***TRANSITIONAL PART 3A ASSESSMENT
Concept Plan Modification MP05_0086 MOD 4
and
Project Application MP11_0046
for
Stage 3 Residential Development, Buildings
11 to 17 at 61 Mobbs Lane, Epping
(Former Channel 7 Site)***

Director-General's
Environmental Assessment Report
Section 75I of the
Environmental Planning and Assessment Act 1979

May 2013

1 Site - Overall(Openspace)
1: 500

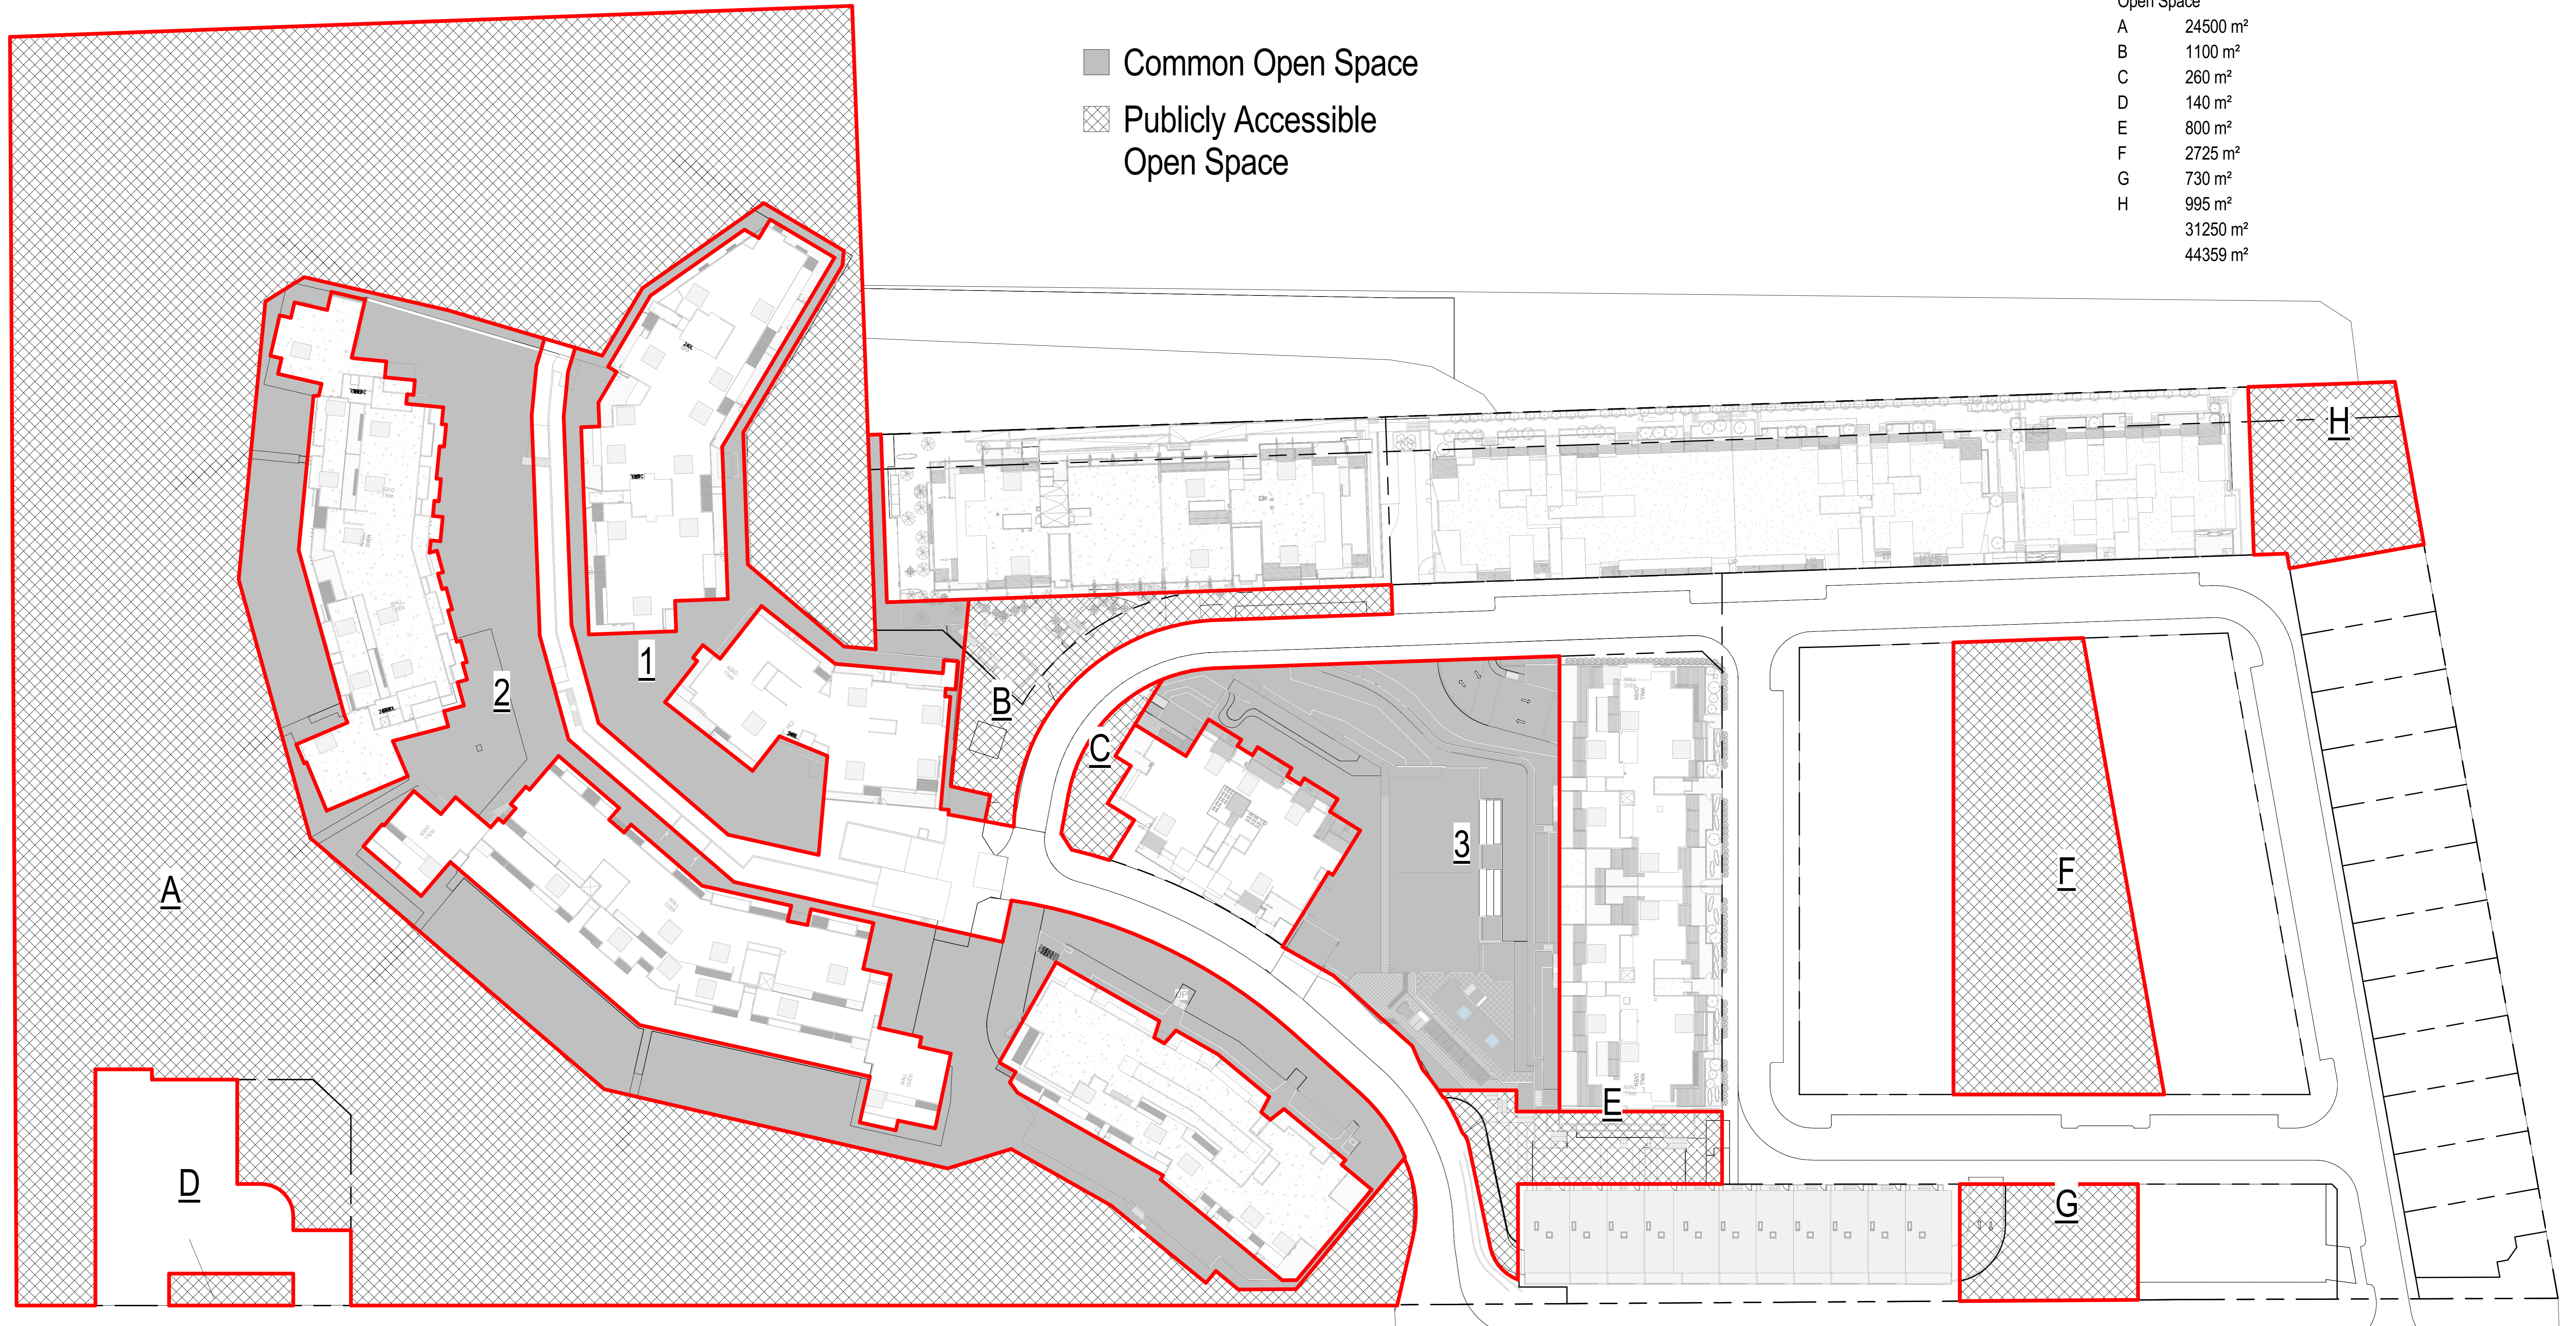
- The council does not support any changes to the VPA for the site, including the proposed changes to the open space provisions in Schedule 1.
